Your Ref: OWPC14730
Our Ref: FG/198/16/PL
Please ask for:
Mr A Wood

27th July 2017

Demolition of existing house with erection of 2 storey building comprising of 8No.
residential 2 bedroom flats & associated external works
1 Sea Drive Ferring

Ferring Parish Council strongly objects to planning application FG/198/16 and all related alterations and revisions.

JOB: 1 SEA DRIVE, FERRING, WORTHING BN12 5HD
DWG: PROPOSED SITE PLAN

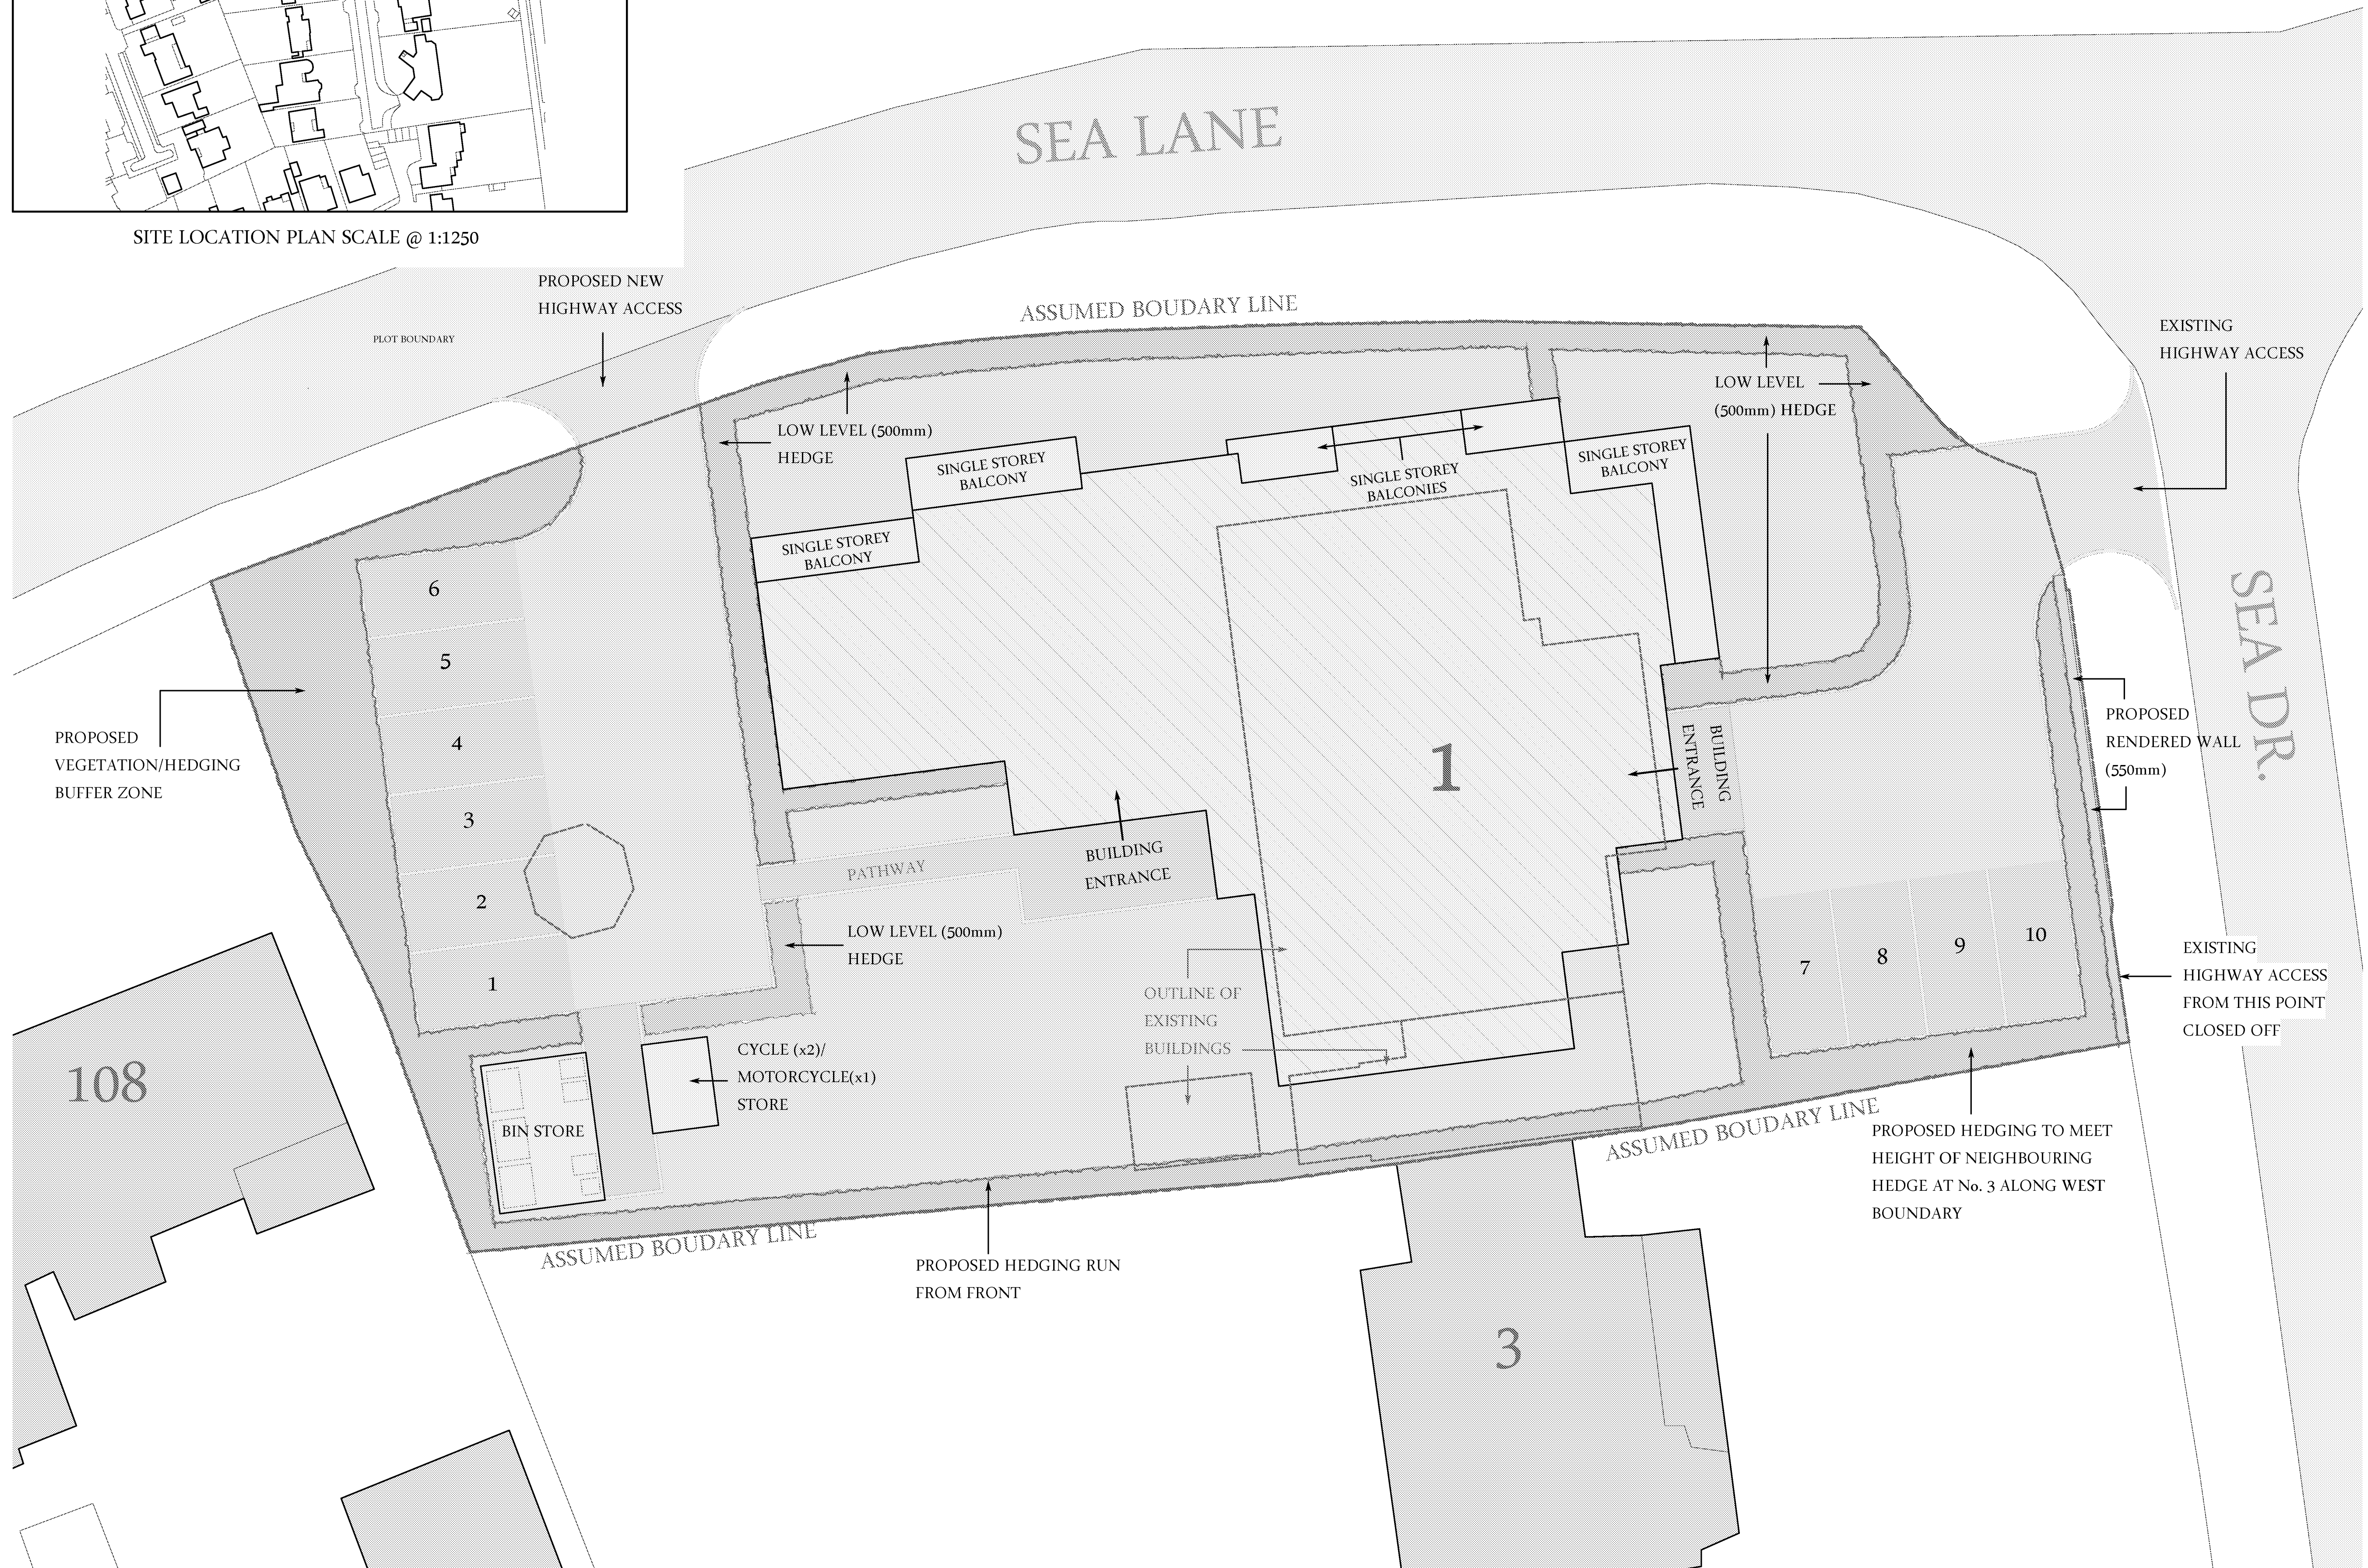
The proposed parking is still inadequate, merely moving lines on a plan does NOT create more parking. The spaces at 2.4m are not wide enough for a standard family car to park centrally in the space and open a door sufficiently for an occupant to exit. (Standard family car 1.86m, first stop position on average car door 0.55m, therefore space required is 2,41m.) It is obvious therefore that at least the two end spaces are effectively unusable. At the time of writing this objection the swept path diagrams are unavailable.
